From:
Sent: 24 May 2026 12:21
To: DC Admin
Subject: Fwd: Urgent Planning application 2026/62/90955/E objection.

In reference to planning application 2026/62/90955/E

Date	16/03/2026	Sheet	2
Scale	1:100

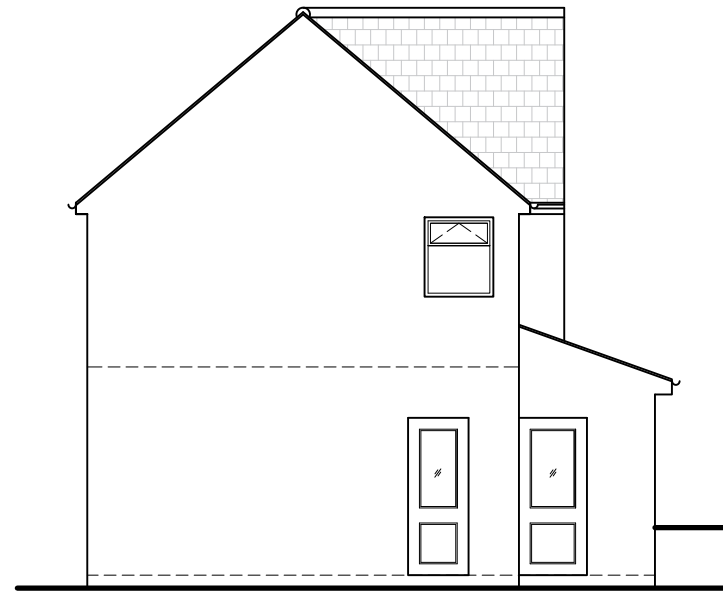
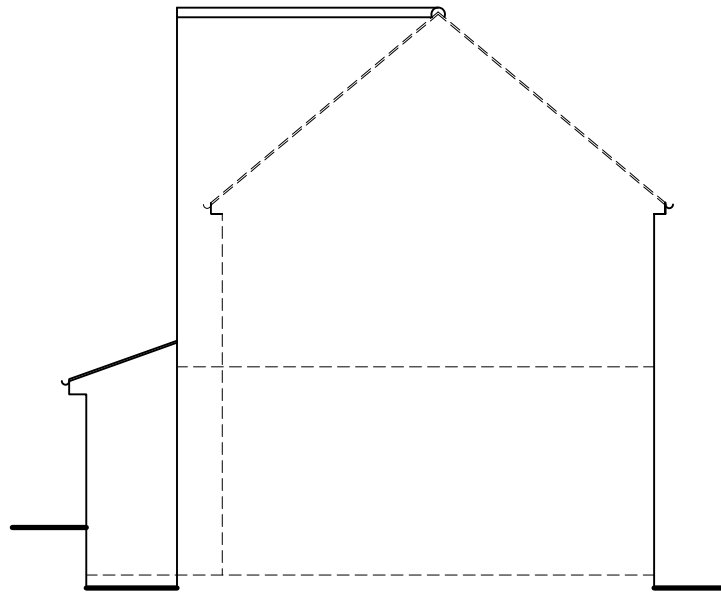
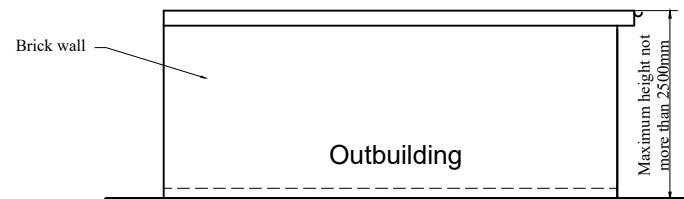
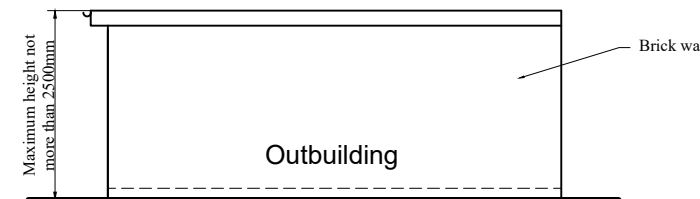
- 2) The proposed outbuild, due to its excessive height and position would create a direct access route from the roadside into our rear enclosed garden. The existing fencing currently prevents such access, however the scale and height of the structure would undermine the boundary protection and create a security risk that at the moment is not the case.

REAR ELEVATION

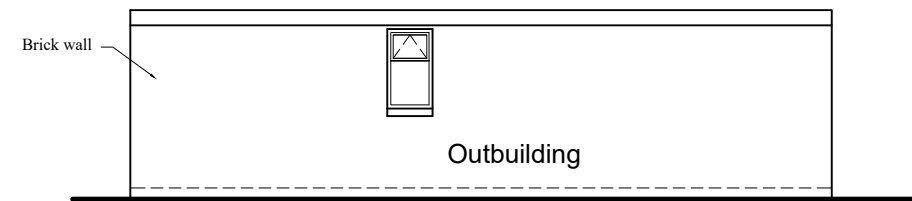
- 3) The rear-facing window would directly overlook neighbouring rear properties situated at a substantially lower level, causing unacceptable loss of privacy. Furthermore, given the hillside elevation, the proposed excavation and structural support works raise serious concerns regarding potential damage to neighbouring land, garden structures, and property foundations. Due to work previously undertaken by the applicant we have already had to undertake extensive work to provide structural support due to them undermining the garden on the boundary.
